PLANNING CONSULTATION RESPONSE

Application No	<u>2026/0260</u>
Proposal	Widening of existing vehicle access/dropped kerb and driveway, part demolition of boundary wall and installation of gate.
Address	540 Carlton Road, Carlton, Barnsley, S71 3JE
Date of Consultation Reply	30/07/26
Consultee	Highways Development Control

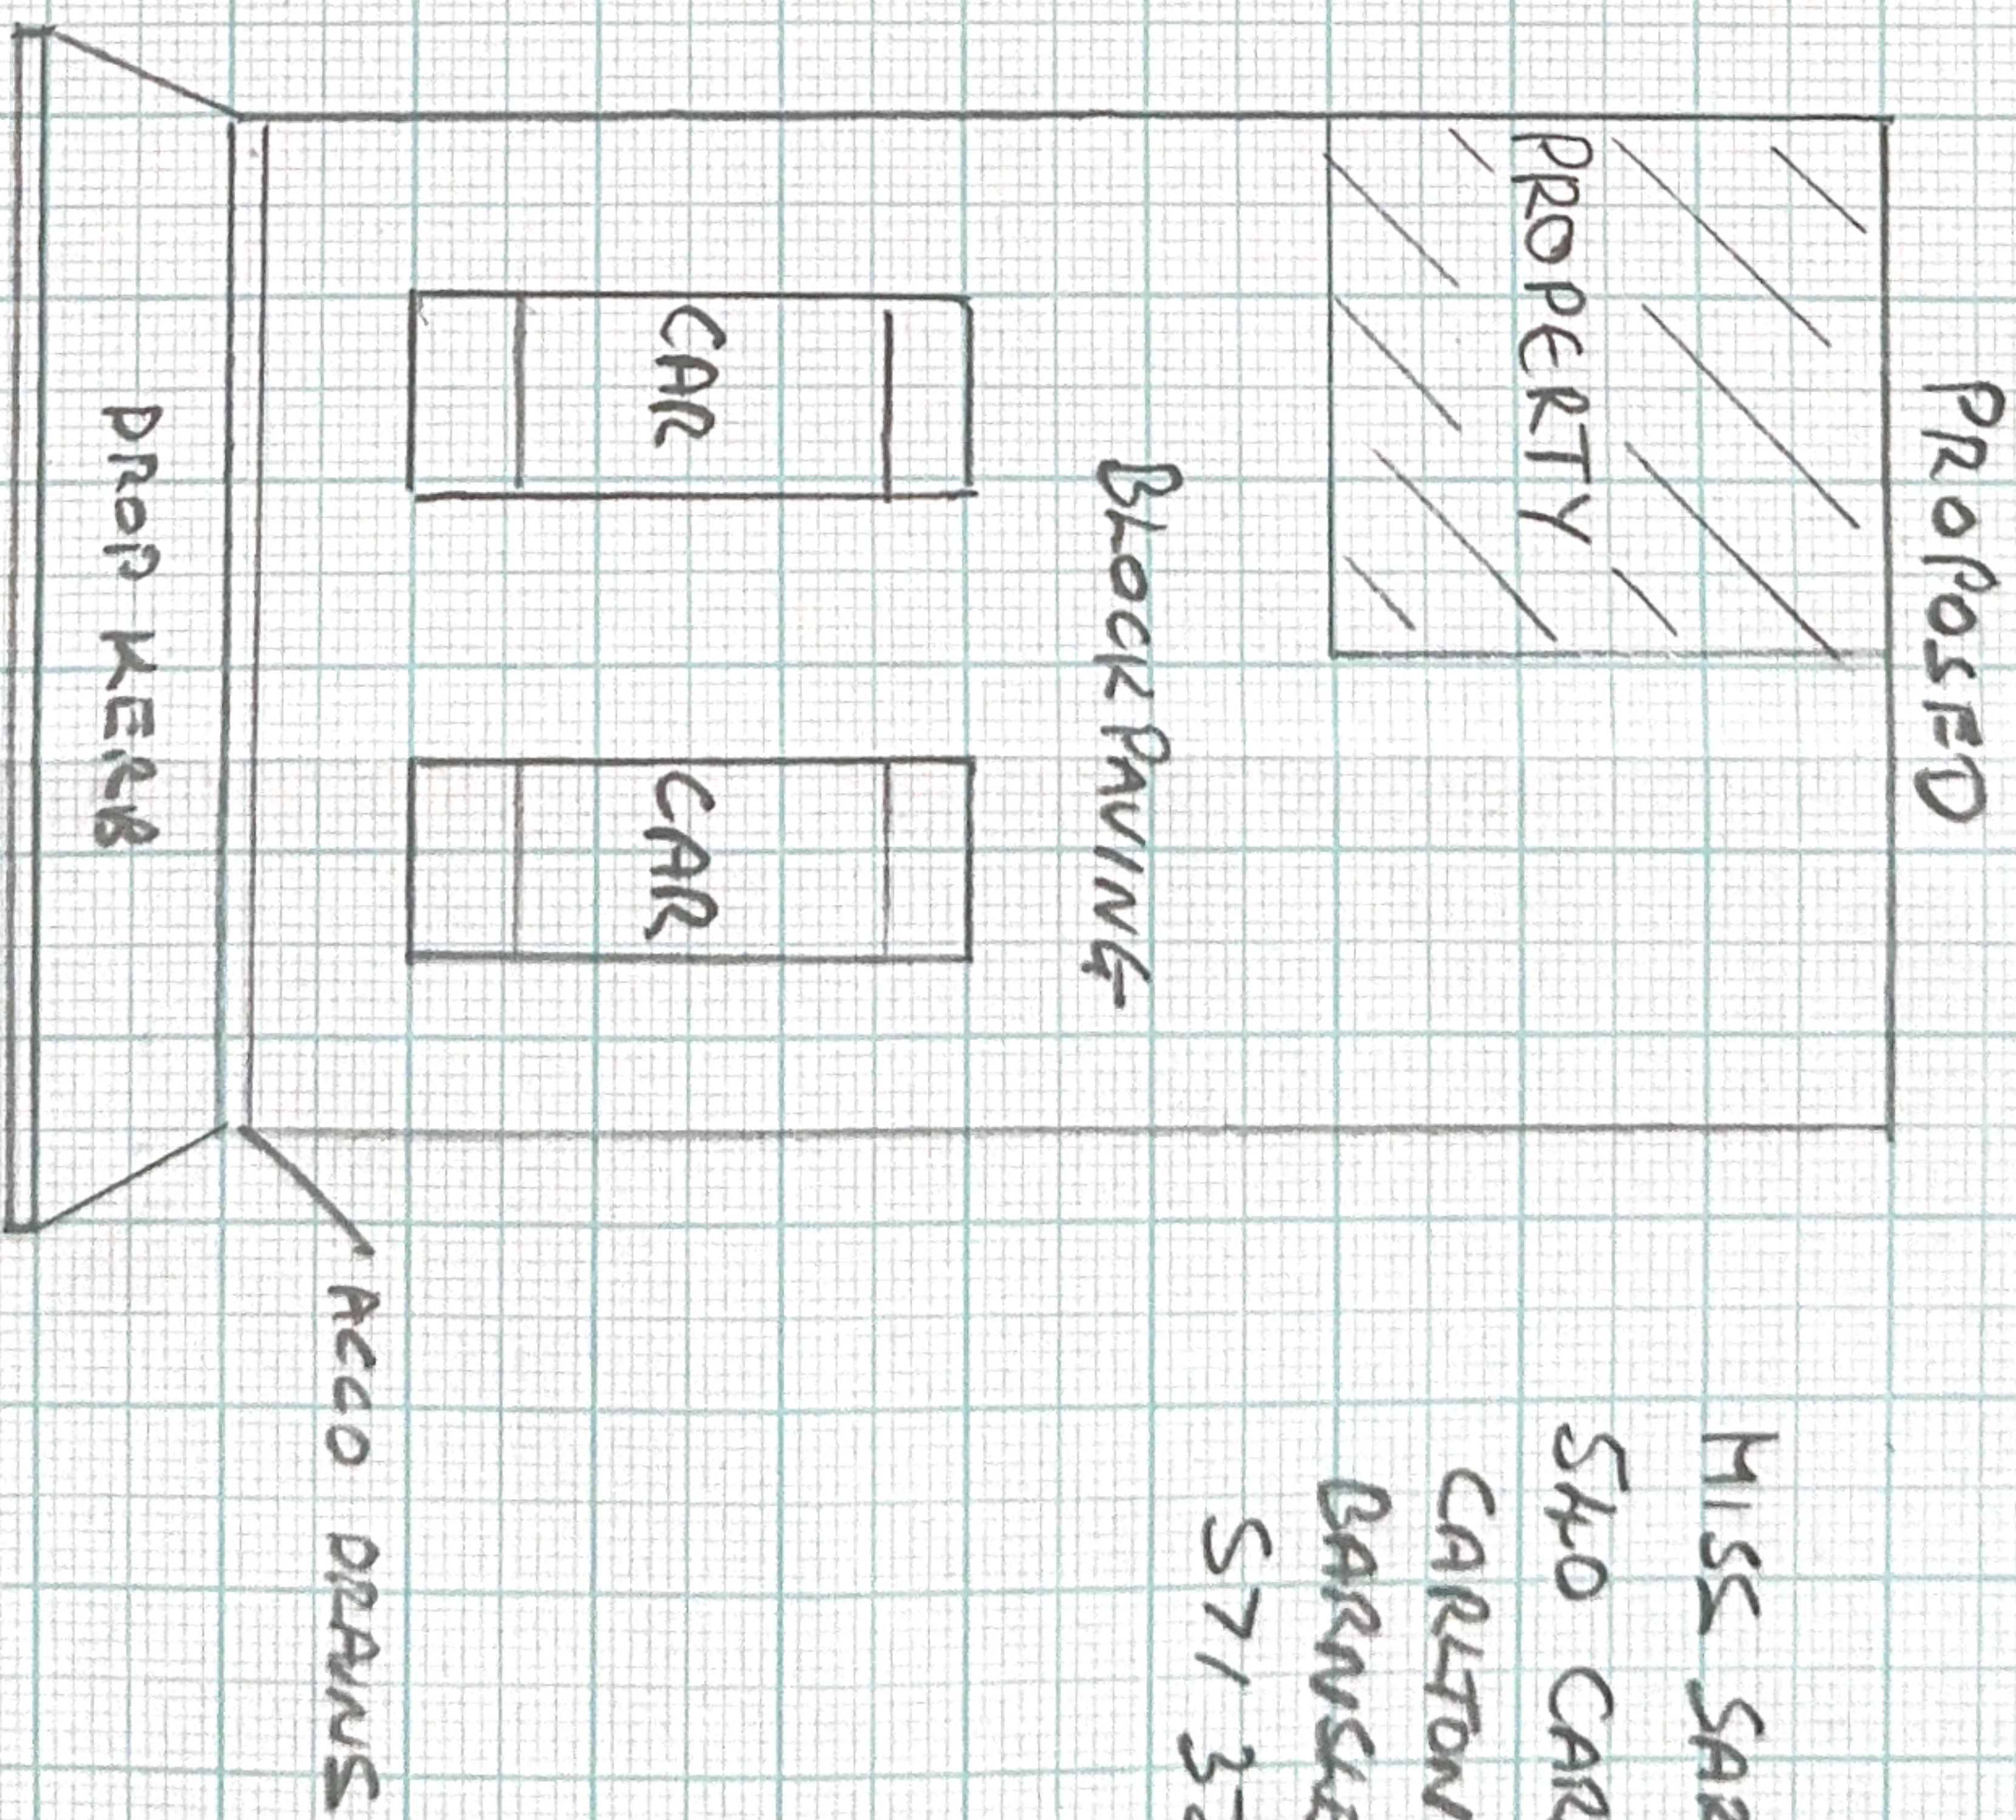
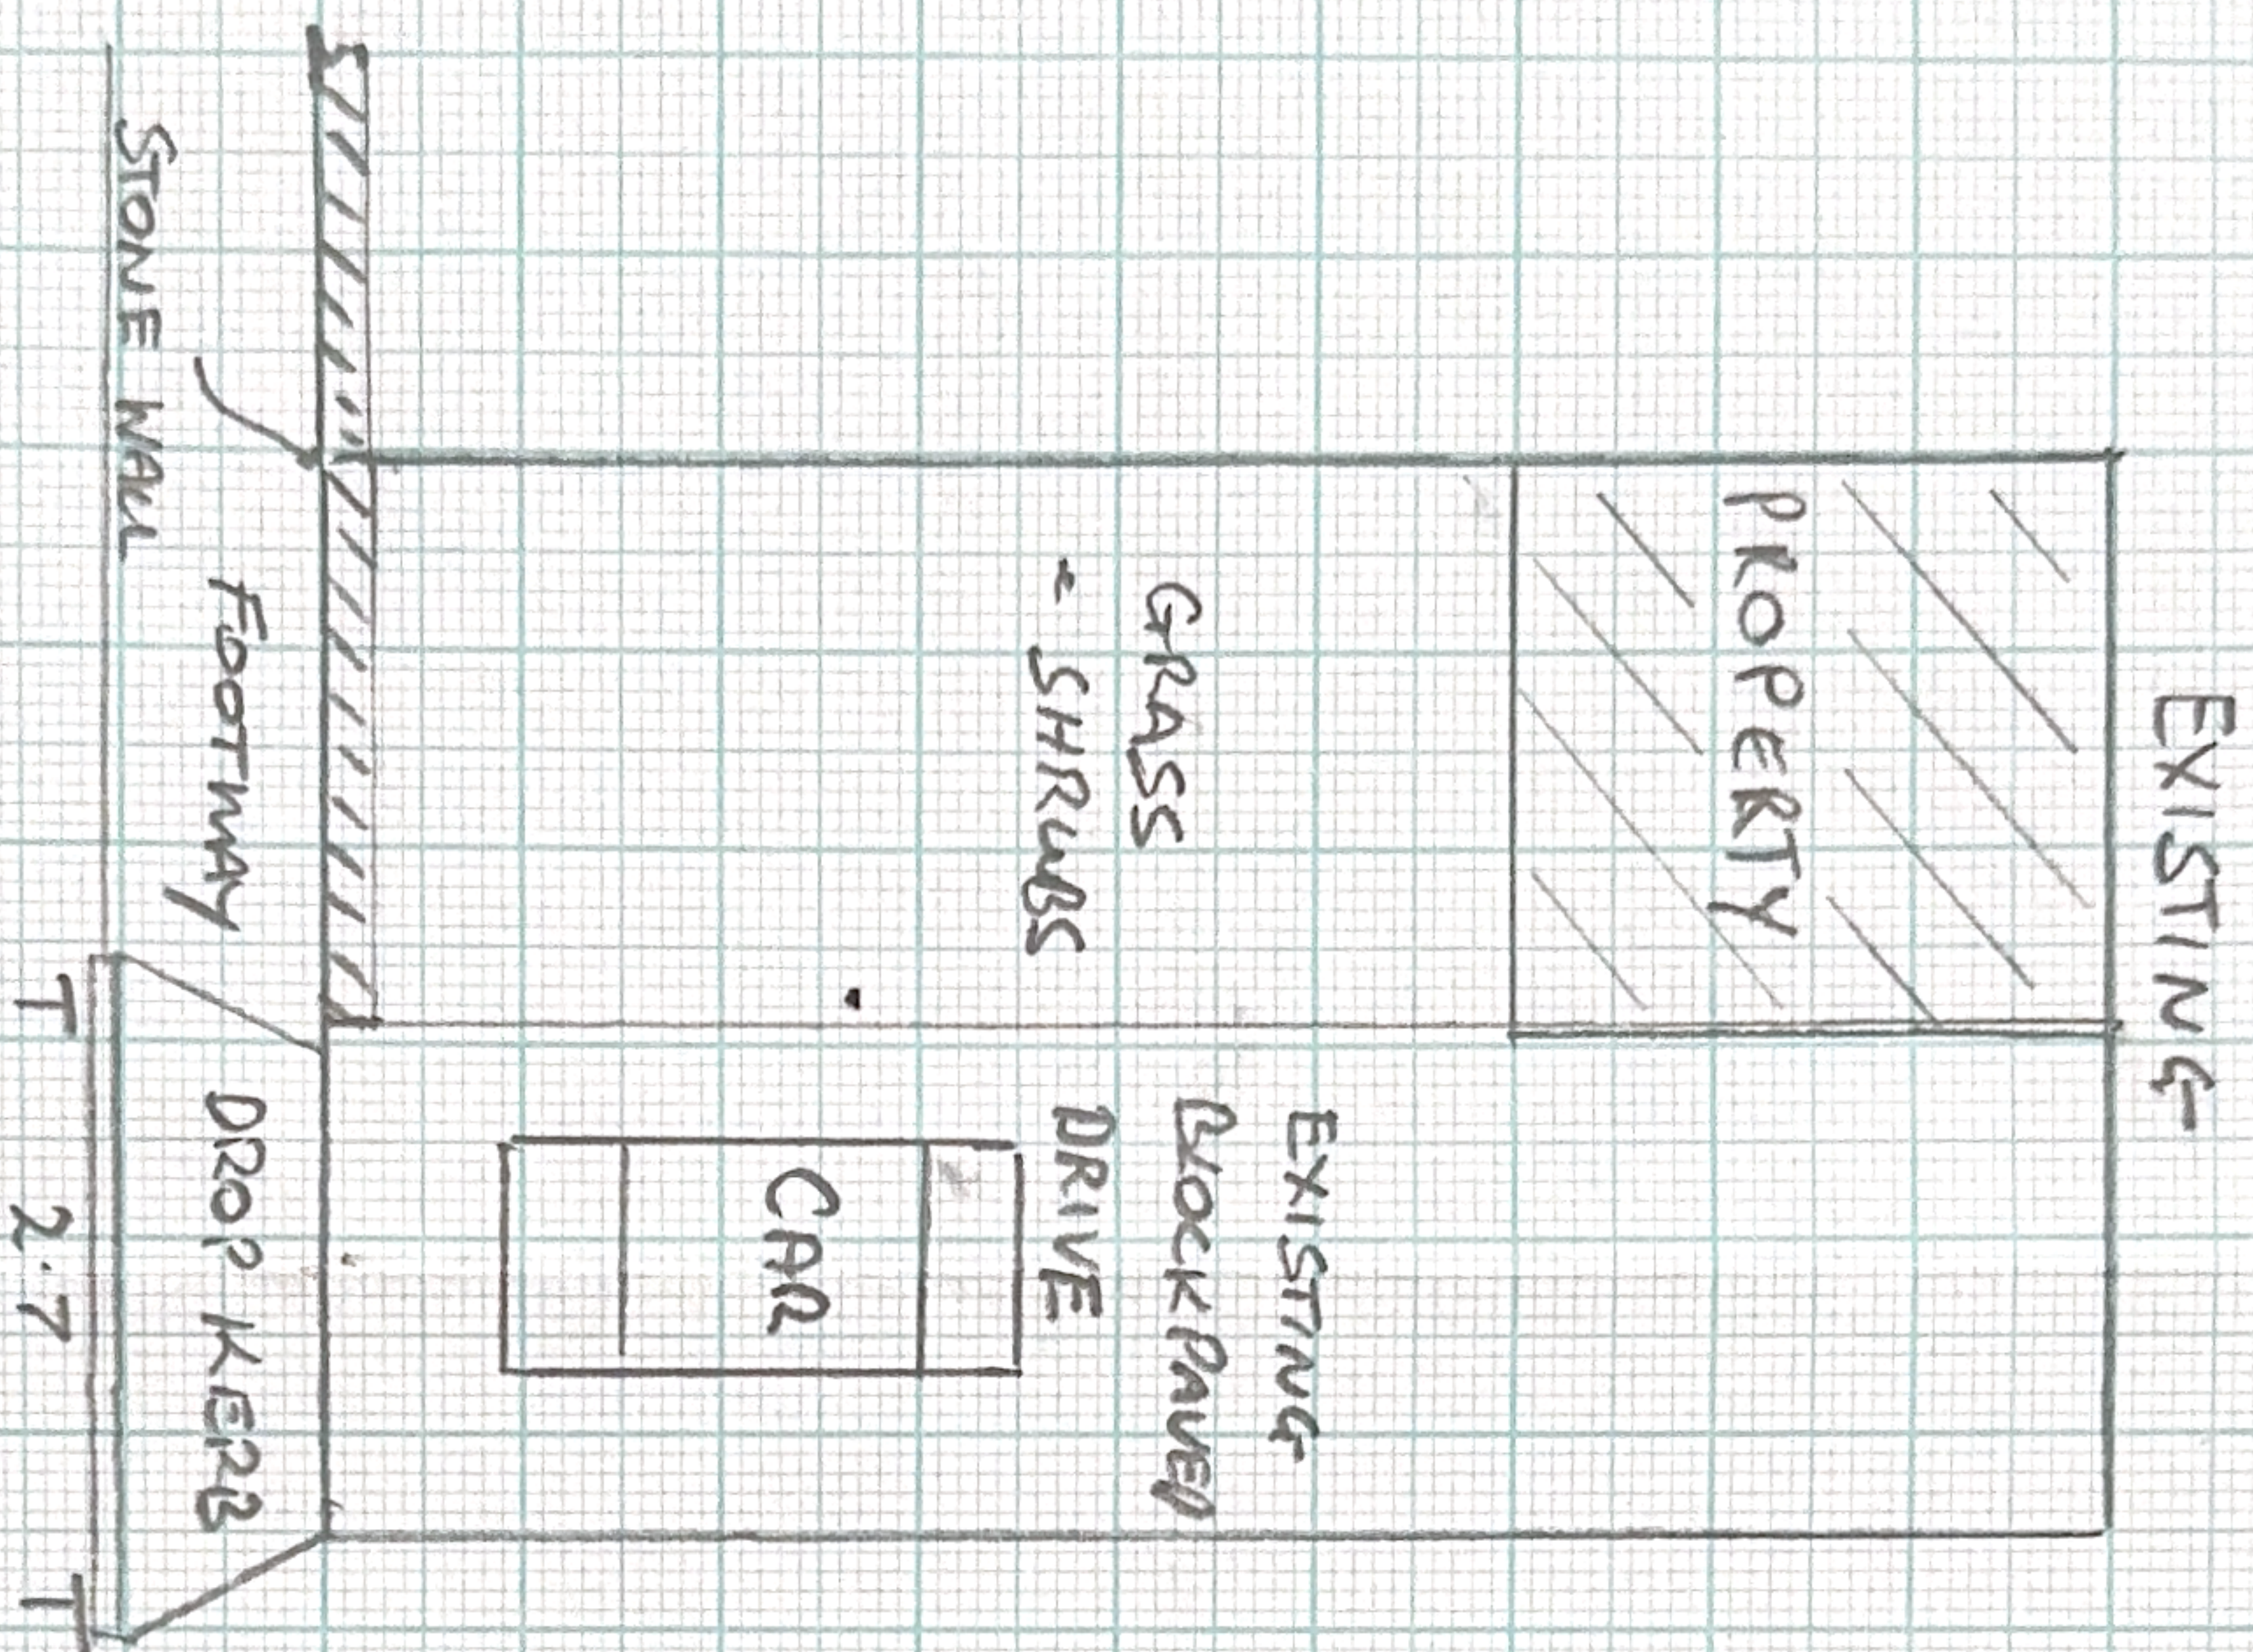
Having reviewed the submitted details, whilst I have no objection in principle to the widening of the existing vehicular access to provide adjacent parking to the front of the property, I would take this opportunity to improve the restricted visibility at the access. The layout should be amended to demonstrate pedestrian intervisibility splays measuring 2 metres by 2 metres on both sides of the access. The boundary wall, gates and planting should be amended as necessary so that the splays remain free from obstruction, and thereafter be retained for the lifetime of the development.

Should the applicant wish to provide amended plans to show the required splay, I would be happy to reassess the application.
